WELWYN HATFIELD BOROUGH COUNCIL – DEVELOPMENT MANAGEMENT
DELEGATED REPORT

APPLICATION No:	S6/2013/1343/FP
APPLICATION Site:	12 Ramsey Close

This application seeks full planning permission for demolition of existing garage and erection of two storey side, single storey front extension and orangery/conservatory.

Drawing: Block Plan

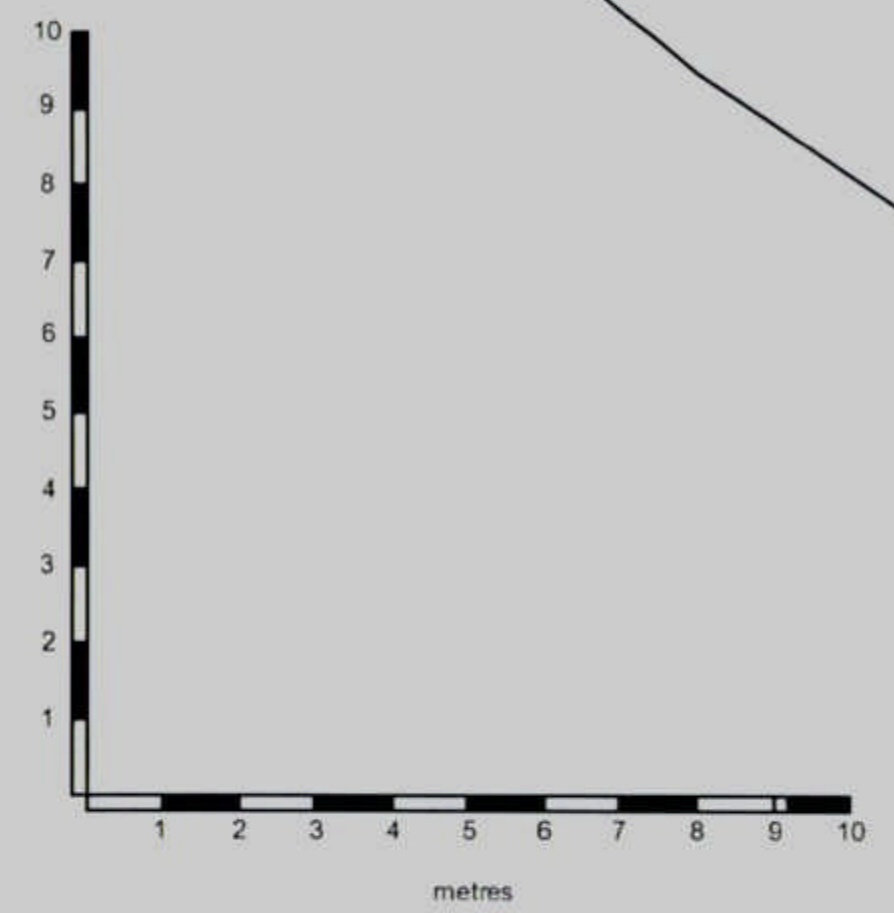
The existing detached garage would be replaced with a two storey side extension which would abut the flank site boundary to the east and project approximately 2m forward of the front wall of the dwelling. The side extension would feature an integral garage and a gable roof with a ridge running front to back. A single storey element would project across the front of the dwelling, finished with a monopitch roof. A single storey orangery is proposed to the rear of the property.

The submitted drawings show that the extended dwelling would provide a total of four bedrooms. The Parking Standards Supplementary Planning Guidance (SPG) identifies the site as within Zone 4 where residential dwellings with four or more bedrooms require a maximum of three car parking spaces which can be provided within the site. Access arrangements would remain unchanged. It is considered that the development would not have an unreasonable impact on the safety and operation of the adjoining highway in accordance with the National Planning Policy Framework; Policy M14 of the Welwyn Hatfield District Plan 2005 and Supplementary Planning Guidance

Drawing:
**Flank Elevation
Proposed**

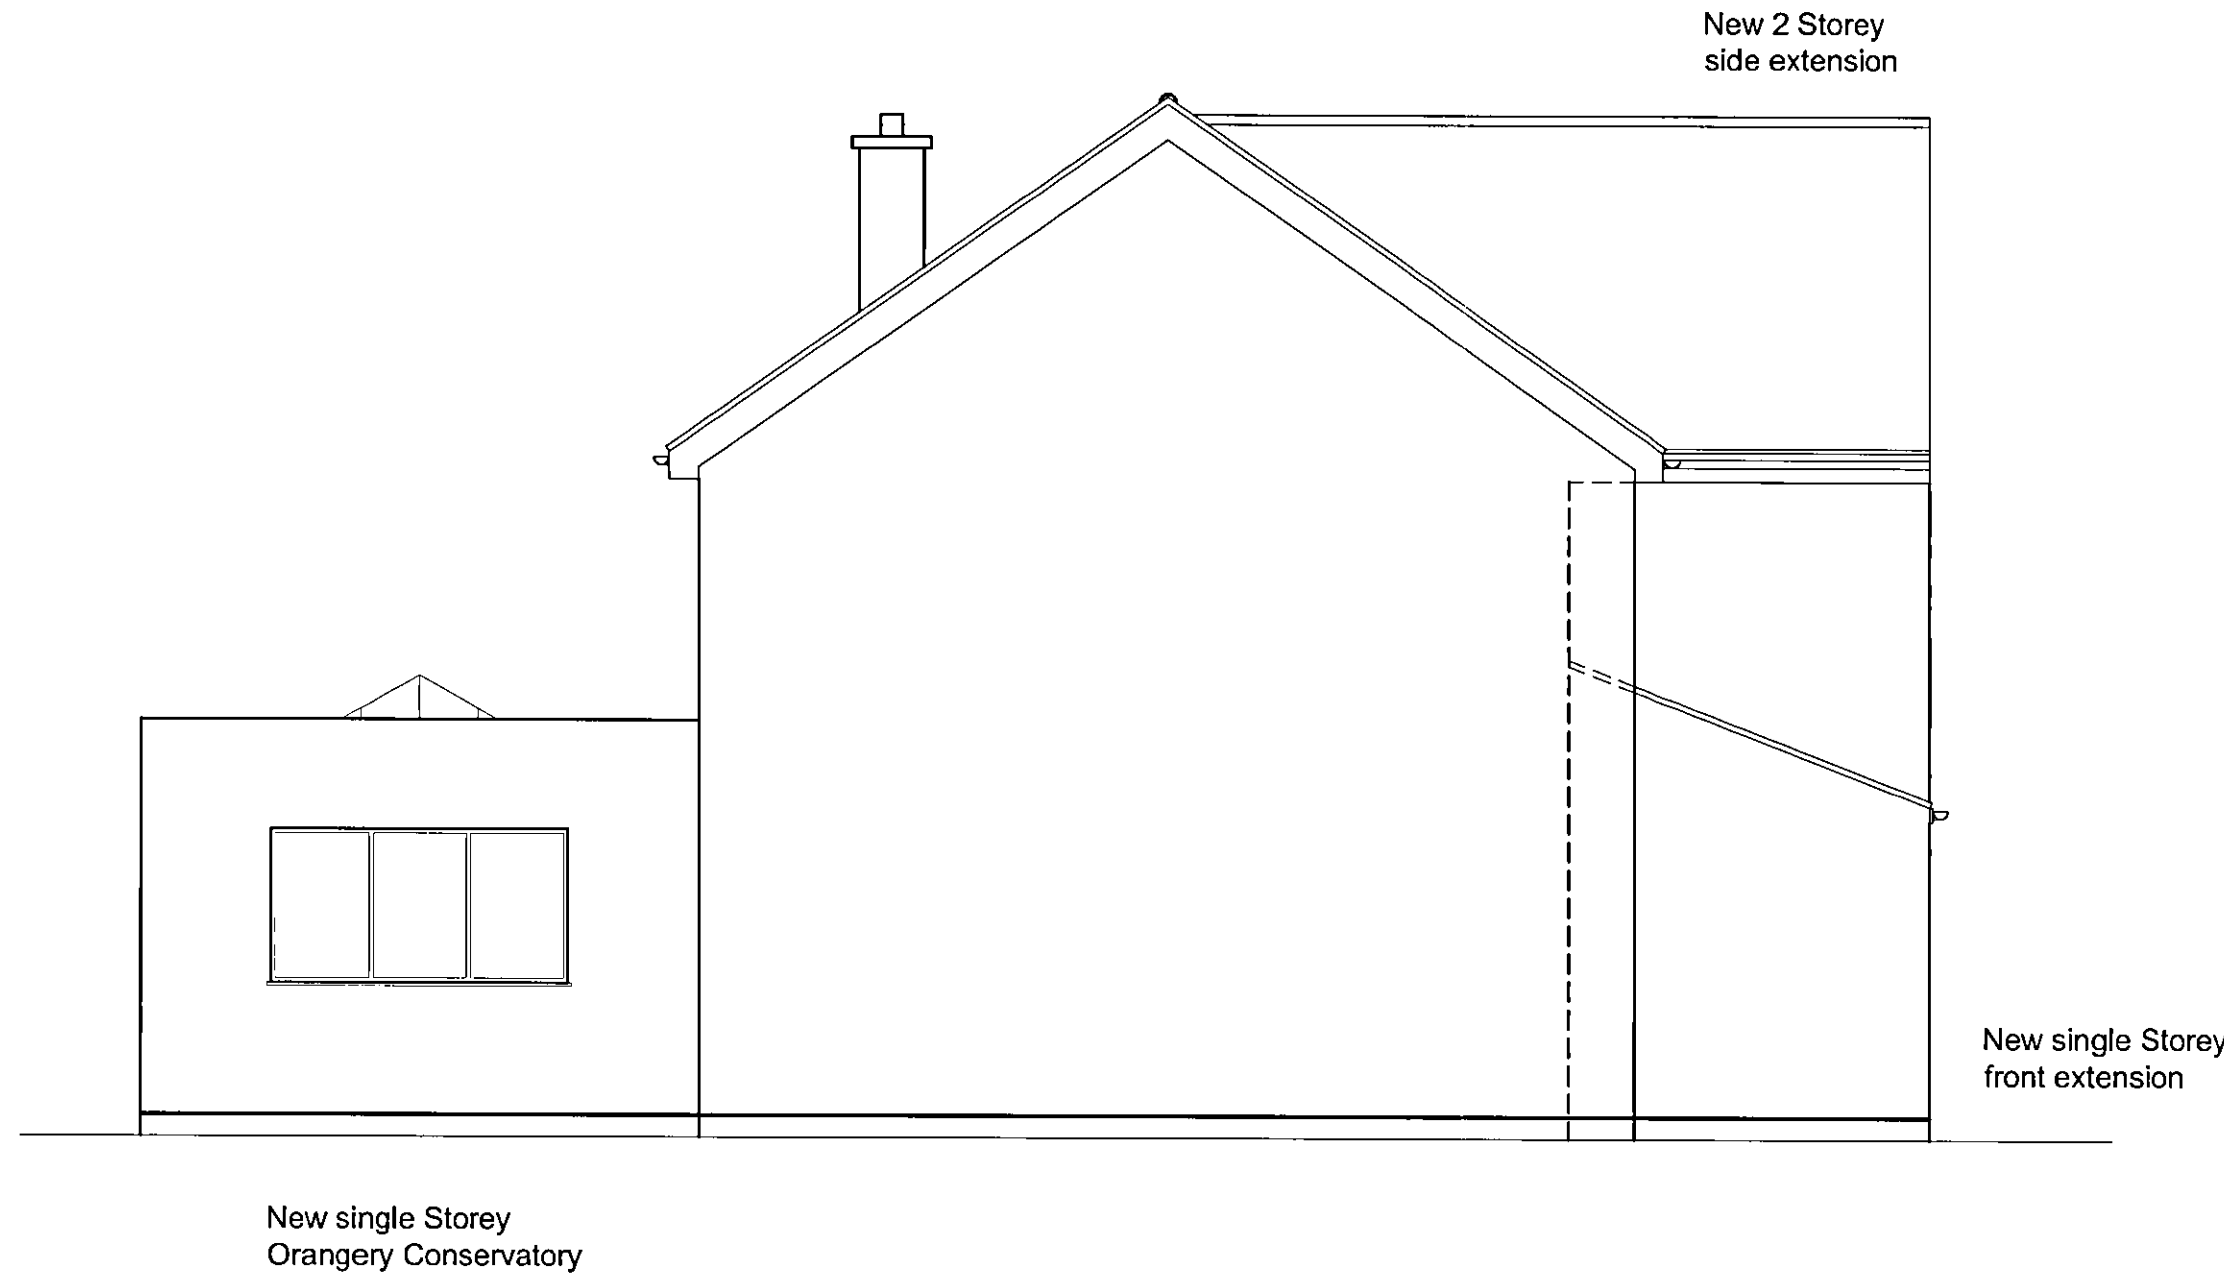
The architectural style and materials proposed would not be out of character with the existing dwelling or neighbouring properties. Notwithstanding this, the two storey extension would abut the flank boundary which fails to comply with the SPG and would reduce the space around the dwelling to such an extent that it would appear cramped on its site. The resultant spacing between No.12 and No.13 would fail to reflect existing spacing in the street scene. Furthermore, due to the spacious layout of the existing dwellings in Ramsey Close, the application property appears as a prominent feature in the street scene; in such circumstances, the proposed scheme would appear very noticeable and would cause significant harm to the character and appearance of the existing dwelling and the locality generally contrary to national and local planning policies.
